Yorkshire Water Services
Developer Services
Sewerage Technical Team
PO BOX 52
Bradford
BD3 7AY

Your Ref: 2023/92966
Our Ref: Z005219

2nd December 2024

Land to the rear of 271 Cliffe Lane, Gomersal, Cleckheaton - Demolition of existing dwelling and erection of 97 dwellings including formation of a new access from Cliffe Lane, landscaping, public open space and all associated infrastructure and engineering works (Revised)

Client Quarters Gomersall			
Project Cliffe Lane Gomersall			
Drawing title Drainage Strategy - On Site			
Drawn RT	Chkd	Date FEB 24	Scale 1/500
Contract No. 23054-C-DR	Drg No. 0100	Revision P4

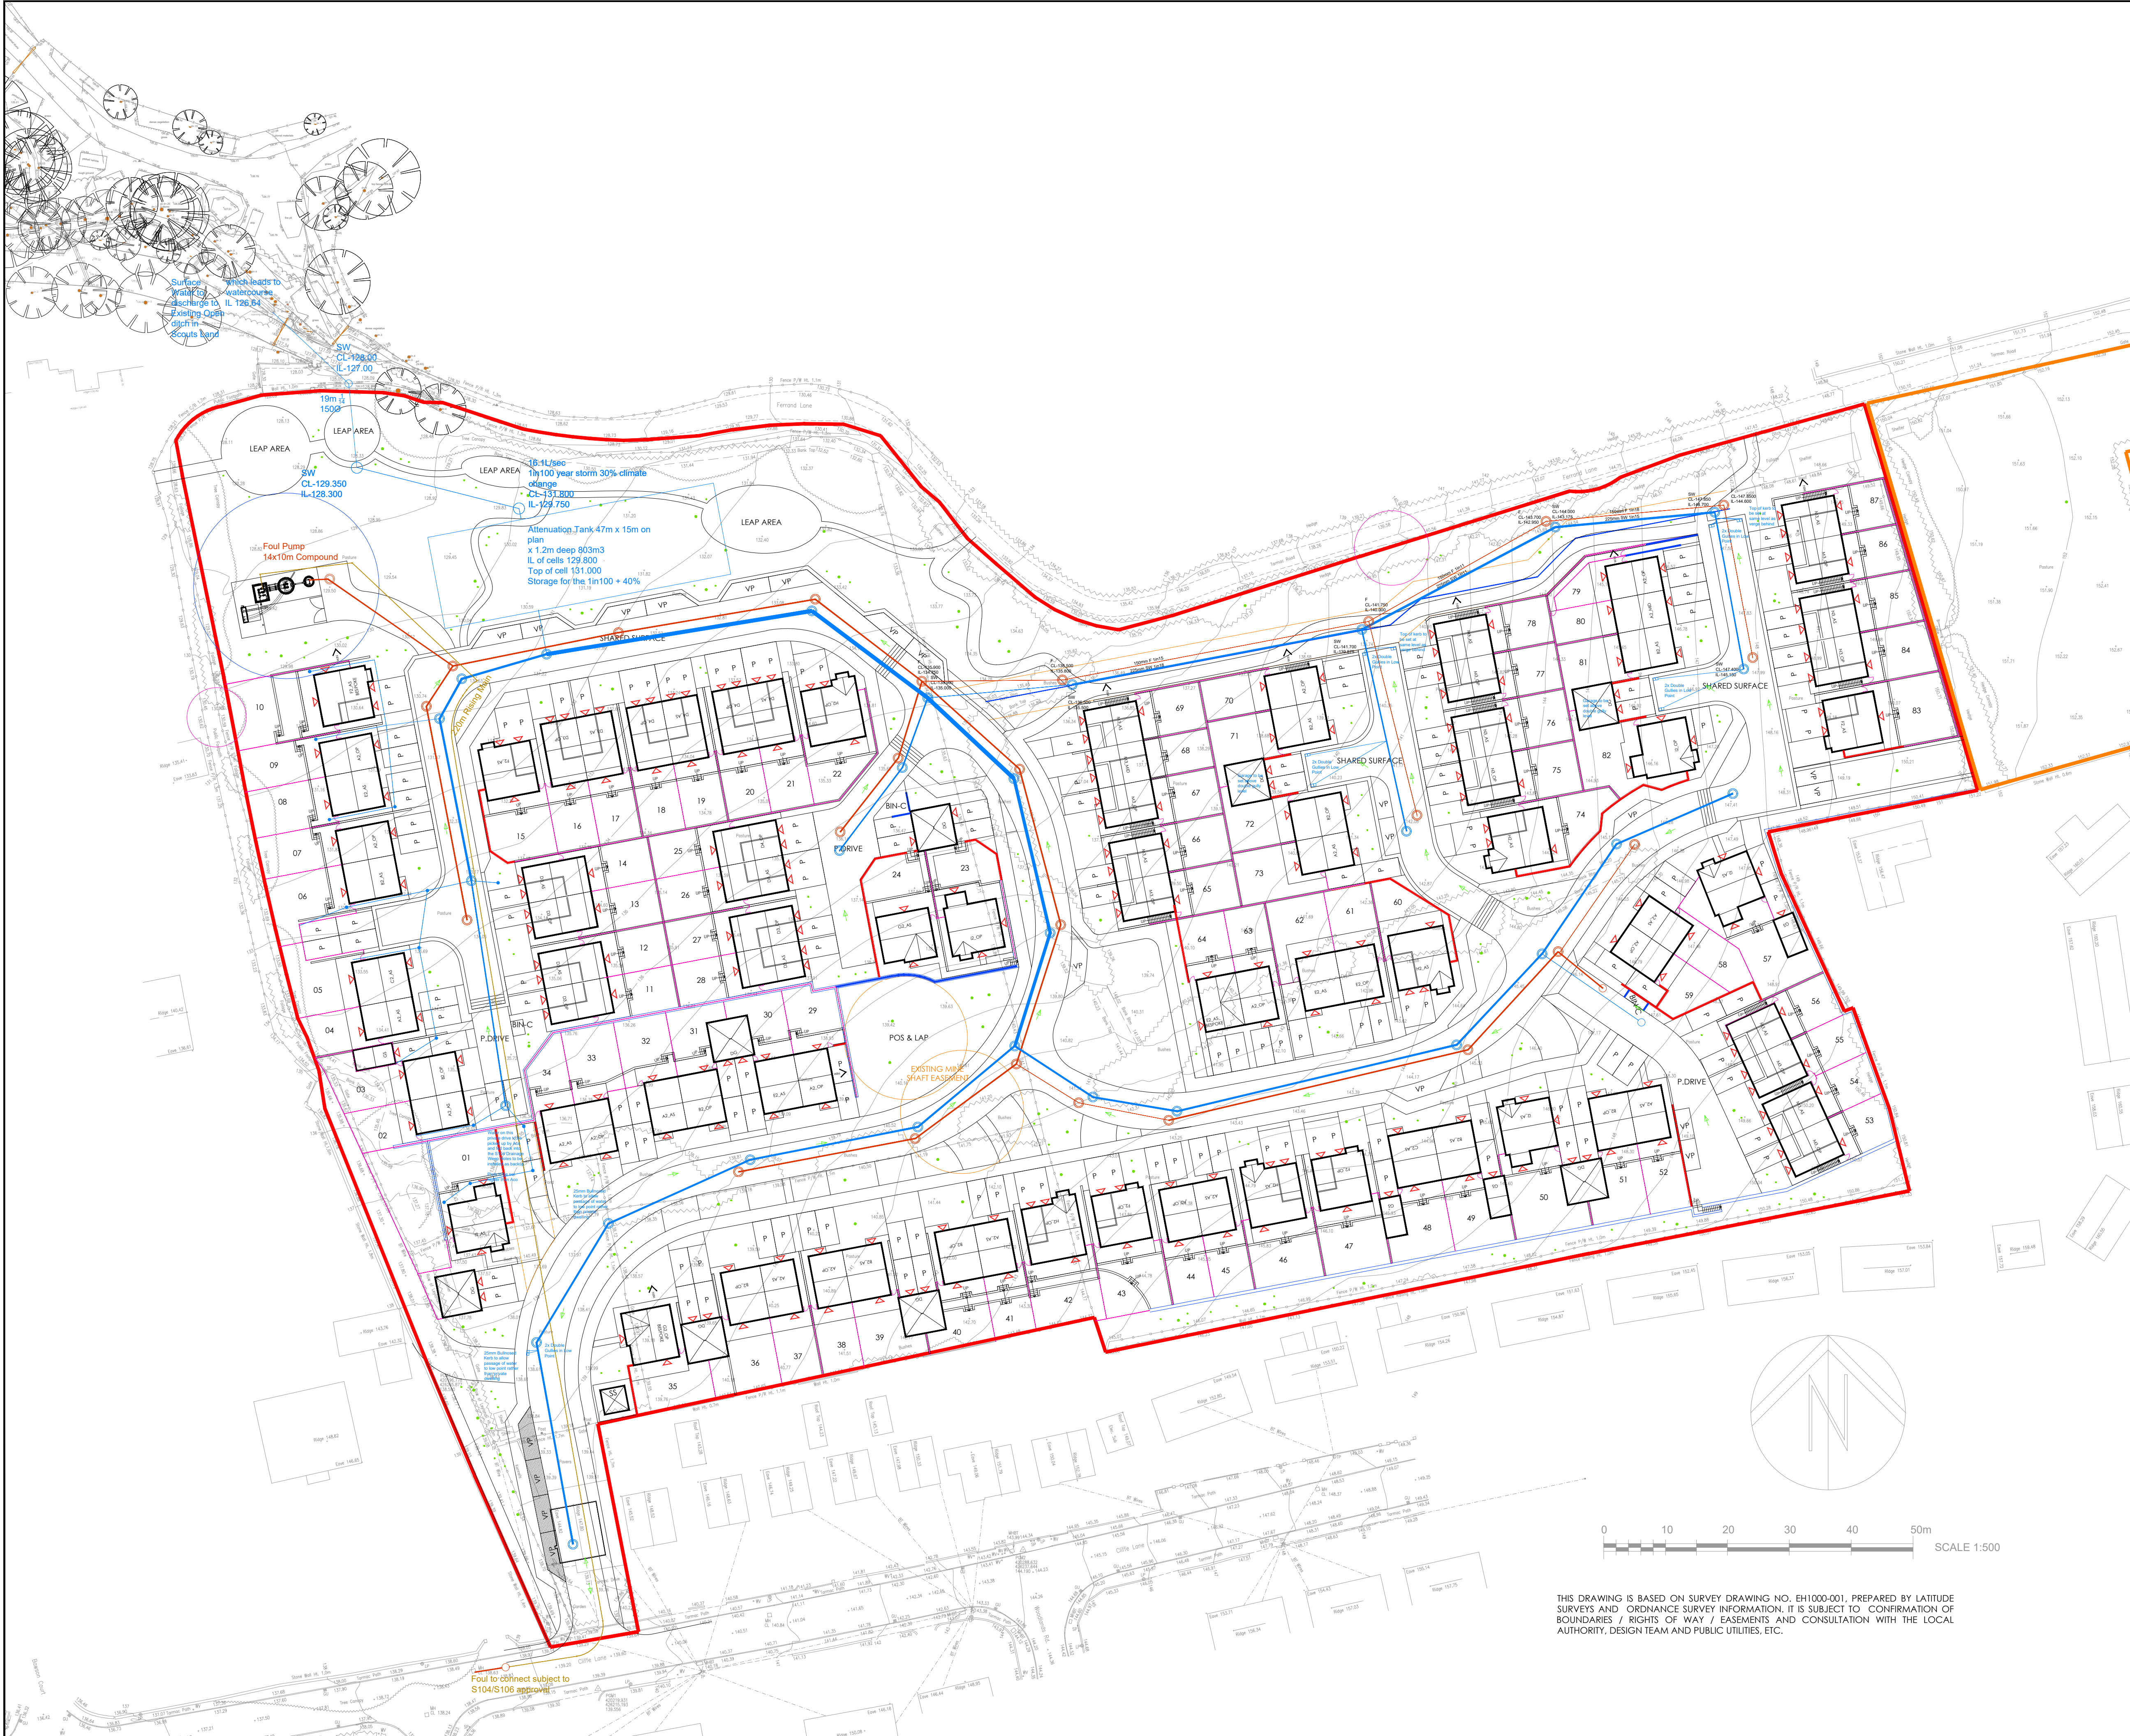
1.) Yorkshire Water has no objection in principle to the drainage details submitted on drawing 'Drainage Strategy - On Site' 23054-C-DR 0100 (revision P8) dated Feb 2024 that has been prepared by Dart, namely: -

- a.) The proposed separate systems of drainage on site and off site
- b.) The proposed amount of domestic foul water to be discharged to the public foul water sewer at a pumped rate of 4.75 litres per second.
- c.) The proposed amount of curtilage surface water to be discharged to watercourse.
- d.) The proposed point(s) of discharge of foul and surface water to the respective public sewers and watercourses.

The development shall be carried out in accordance with the details shown on the submitted plan, "Drainage Strategy - On Site' 23054-C-DR 0100 (revision P8) dated Feb 2024 that has been prepared by Dart", unless otherwise agreed in writing with the Local Planning Authority.
(In the interest of satisfactory and sustainable drainage)
